RE: 2380 Tenth Line Road
Zoning By-law Amendment (D02-02-25-0083) & Site Plan Control Proposal
(D07-12-25-0145)

On January 5, 2026 the City of Ottawa provided the following comments in regard to the Zoning By-law Amendment and Site Plan Control applications. Please see below in red the comment responses:

Figure 9: Excerpt from Site Plan prepared by Neuf Architects, Revision J dated September 29, 2025.

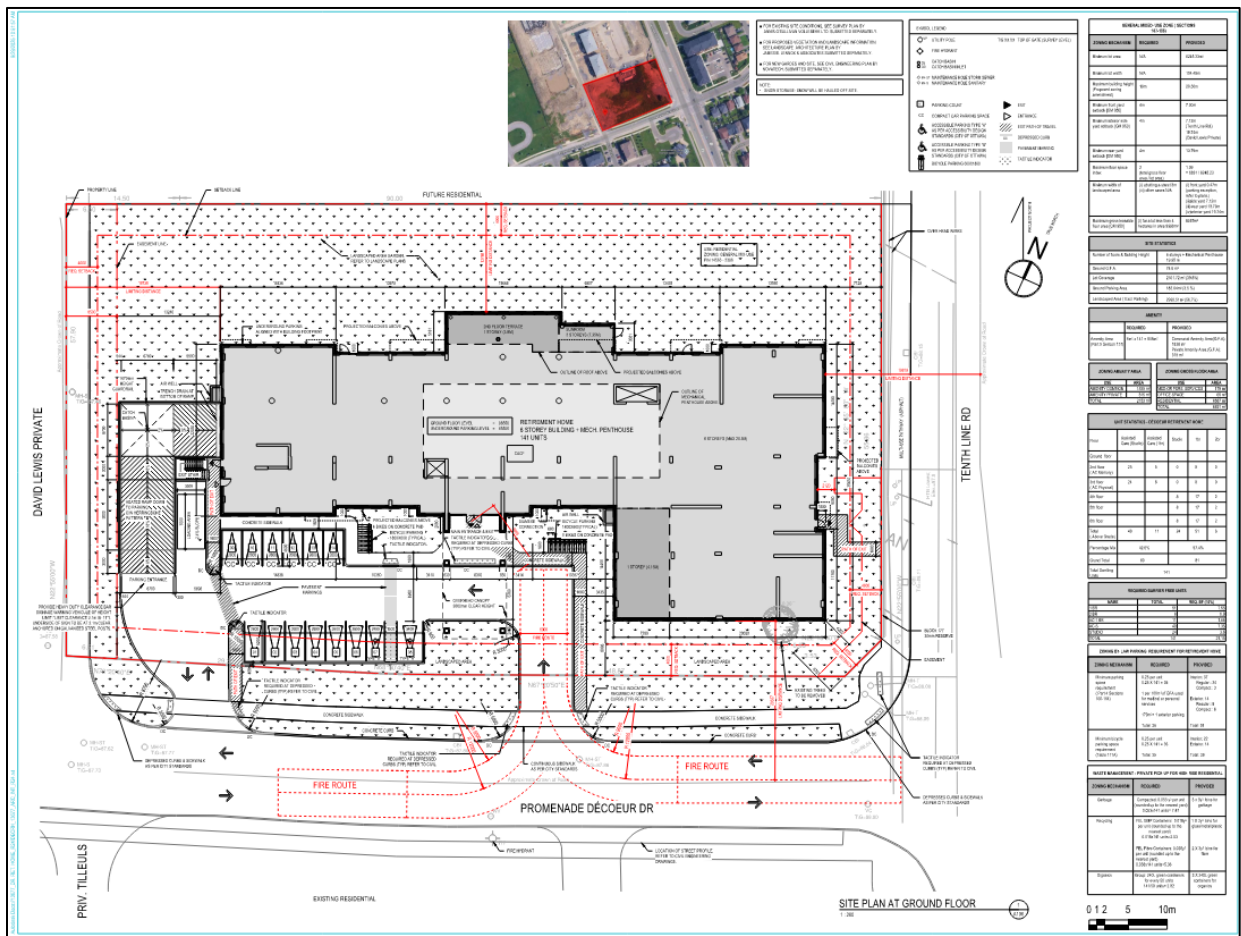
C6.2.4 Access: There are possible sight issues having the private road access and the western private approach so close to together. This does not meet the setback requirement in the PABL for setback to intersection and setback to another private approach on the same lot. Is there any way to bring access from David Lewis Private instead and minimize private approaches to Promenade Decoeur?

C8. Site Plan: Remove TWSIs from sidewalk at site accesses. Build with a continuous sidewalk across per SC7.1

- C17. As per comments from TES above, consider providing access to the parking garage from the back of the property at David Lewis Private, see sketch below:

- C18. On Site Plan:

- a. Show all details of the roads abutting the site; include such items as pavement markings, signage, accesses, on-street parking, and/or sidewalks.

- b. Show dimensions for site elements (i.e. lane/aisle widths, access width and throat length, parking stalls, sidewalks, pedestrian pathways, etc.)

- c. Note that underground ramps should be limited to a 12% grade and must contain a subsurface melting device when exceeding 6%. Ramp grades greater than 15% can be psychological barriers to some drivers. When the underground parking ramp's break over slope exceeds 8%, a vertical-curve transition or a transition slope of half the ramp slope should be used. Without this transition, bottoming out of vehicles may occur.

- C19. Ensure the tree proposed between the western site access and David Lewis Private does not impede sight lines.

Per City request, all outbound access has been moved to David Lewis Private.

The Site Plan has been updated.

Per City request, the proposed access to the parking garage has been moved to David Lewis Private.

Available information regarding pavement markings, signage and access has been added to the Site Plan.

Site elements are dimensioned on the site plan with the exception of landscape features which are dimensioned and detailed on submitted Landscape Architect plans.

Underground parking ramp includes slope transitions and has been reduced to the minimum possible slopes while respecting the site conditions and property limits. Ramp is heated and has been reviewed by the Civil engineers.

Refer to landscape architect plans. Corner triangles have been clearly identified on Site Plan.
